Accessibility Assessment Report

Project Name: Macarthur Gardens North R3

Location: Site 'R3' within the MGN Precinct Lot 1097 in DP1182558.

Axis Reference Number: SSD-80482713 - 15355

-1. BASEMENT 01
Scale 1:200

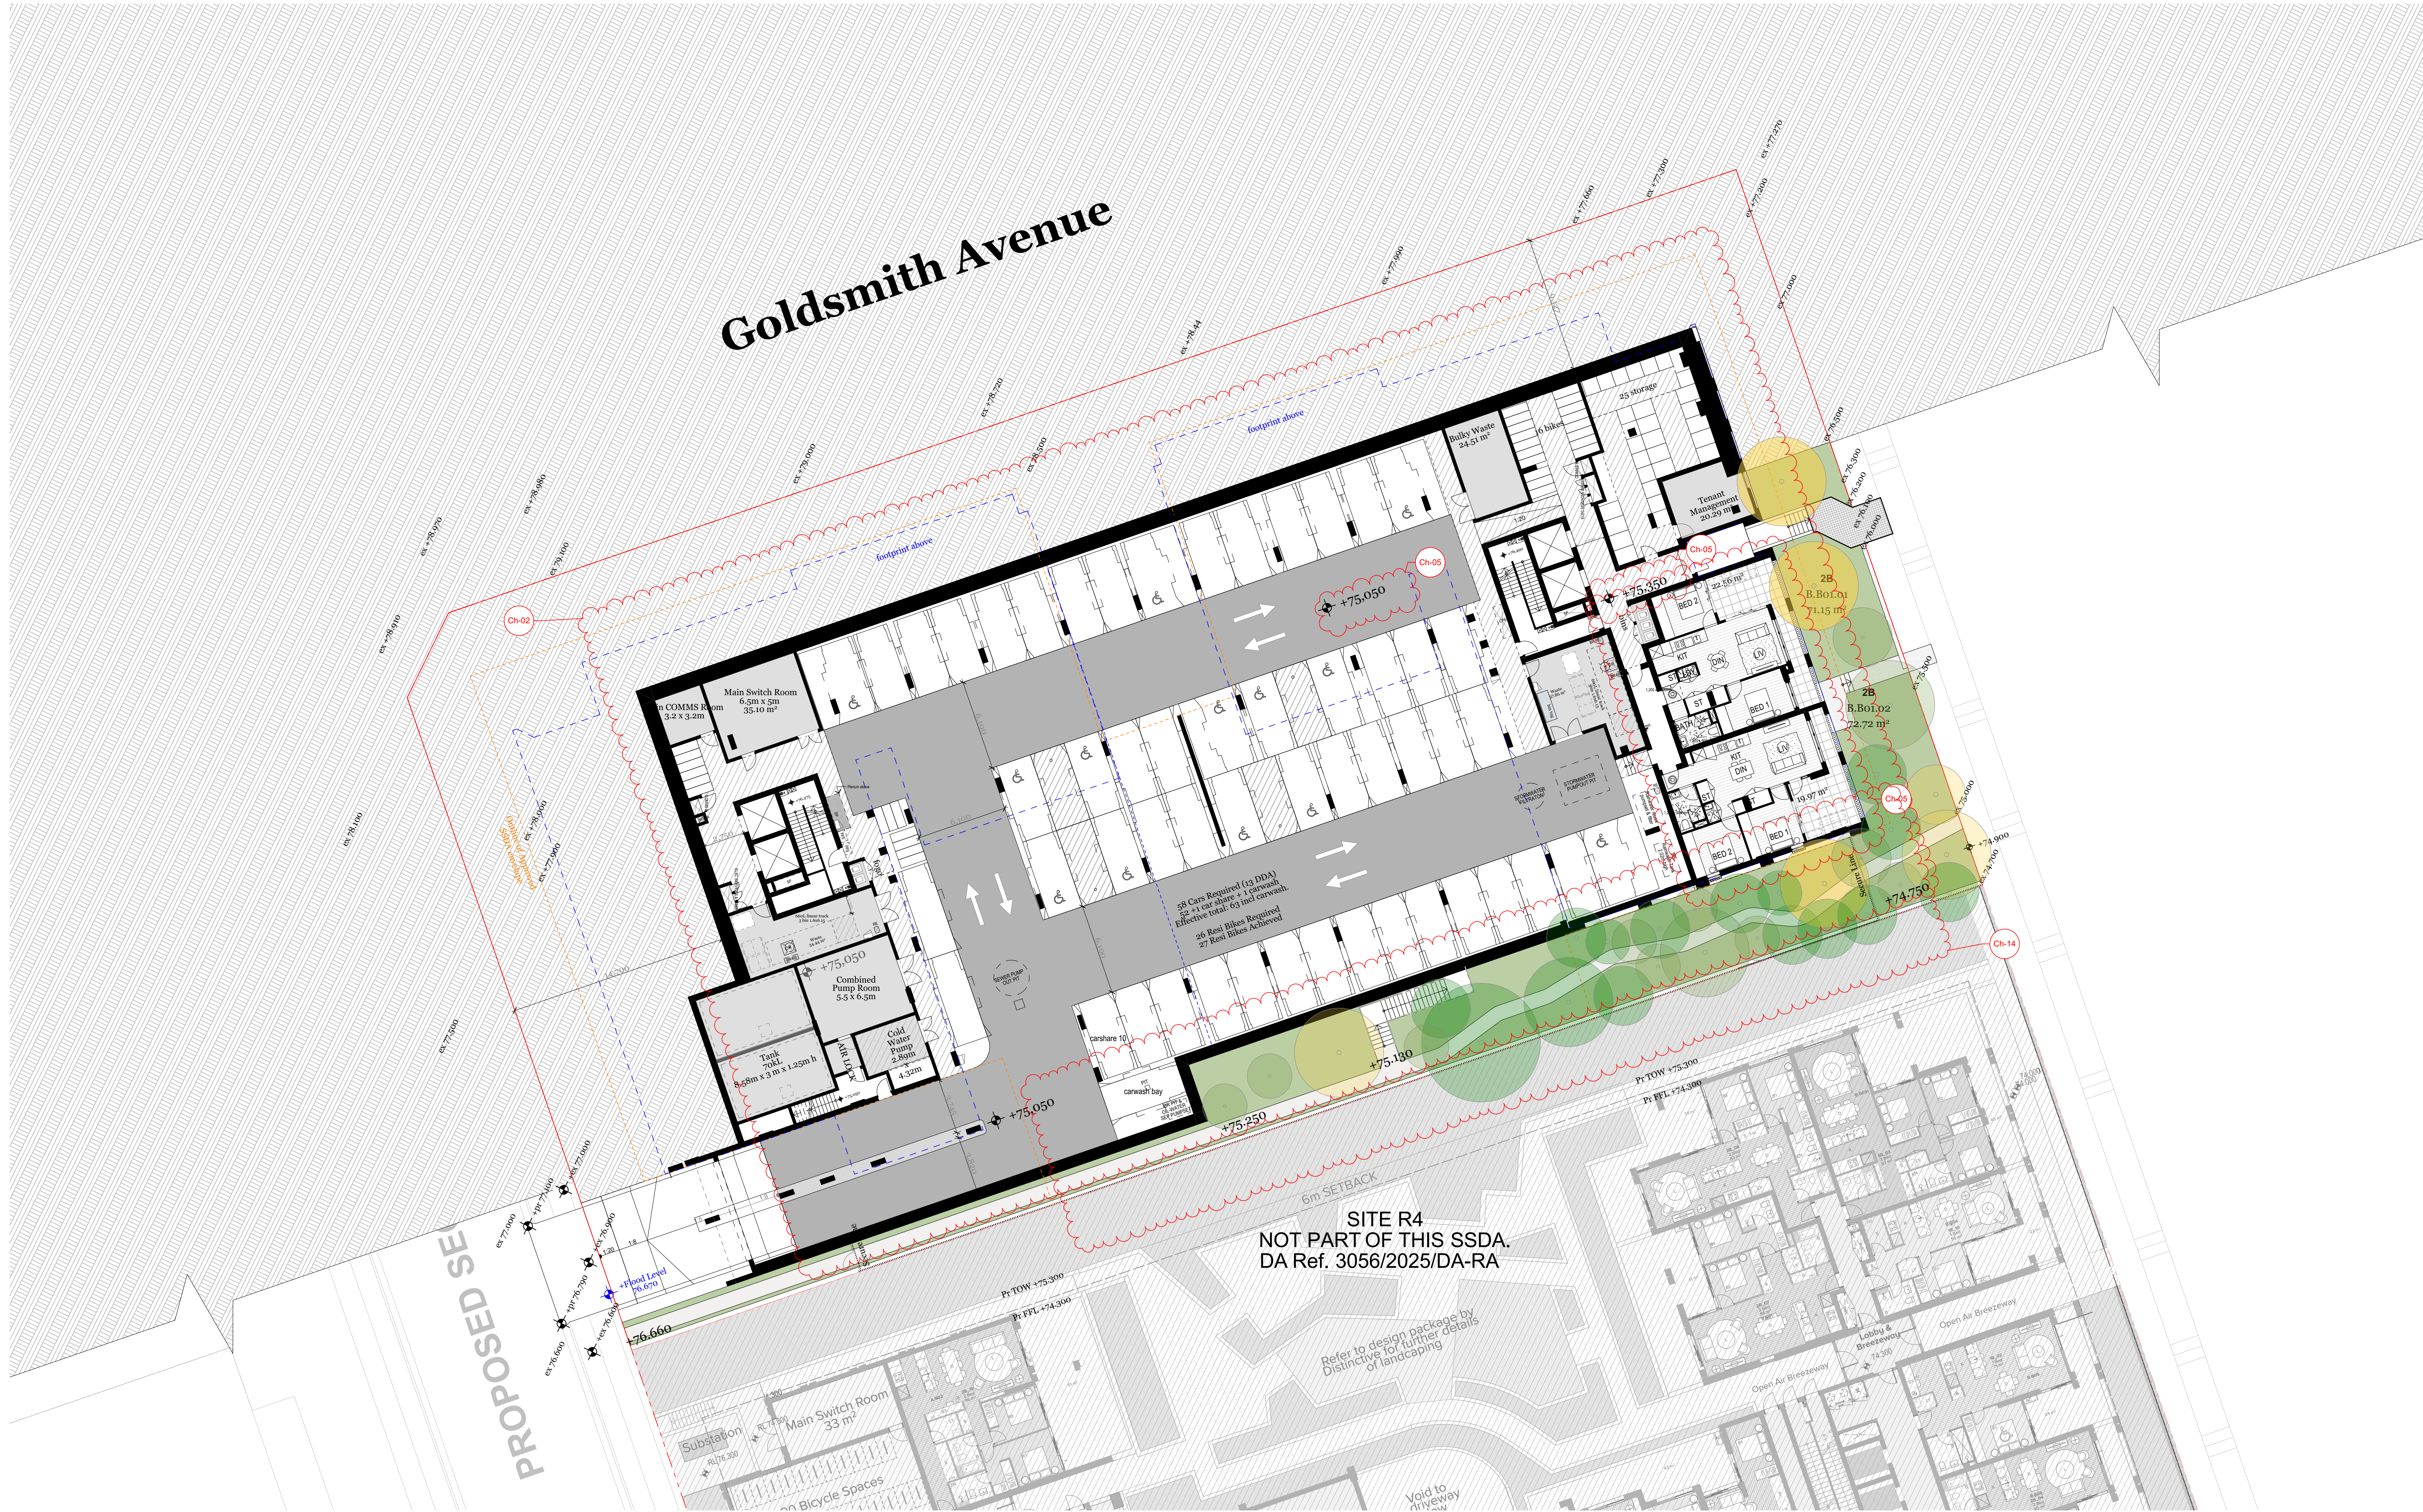
The basement design indicates eight (8) accessible car parking spaces with shared spaces all in accordance with the requirements of AS2890.6.

The basement design indicates five (5) car parking spaces achieving the intent of AS4299 clause 3.7.2 with 5.4m x 3.8m is provided, containing structural columns infringing each dedicated space provided.

A performance solution will be required to justify the current arrangement with the intent of AS4299 achieved to the degree necessary whilst also achieving the spatial requirements of clause 5.2 and Figure 5.2 of AS2890.1.
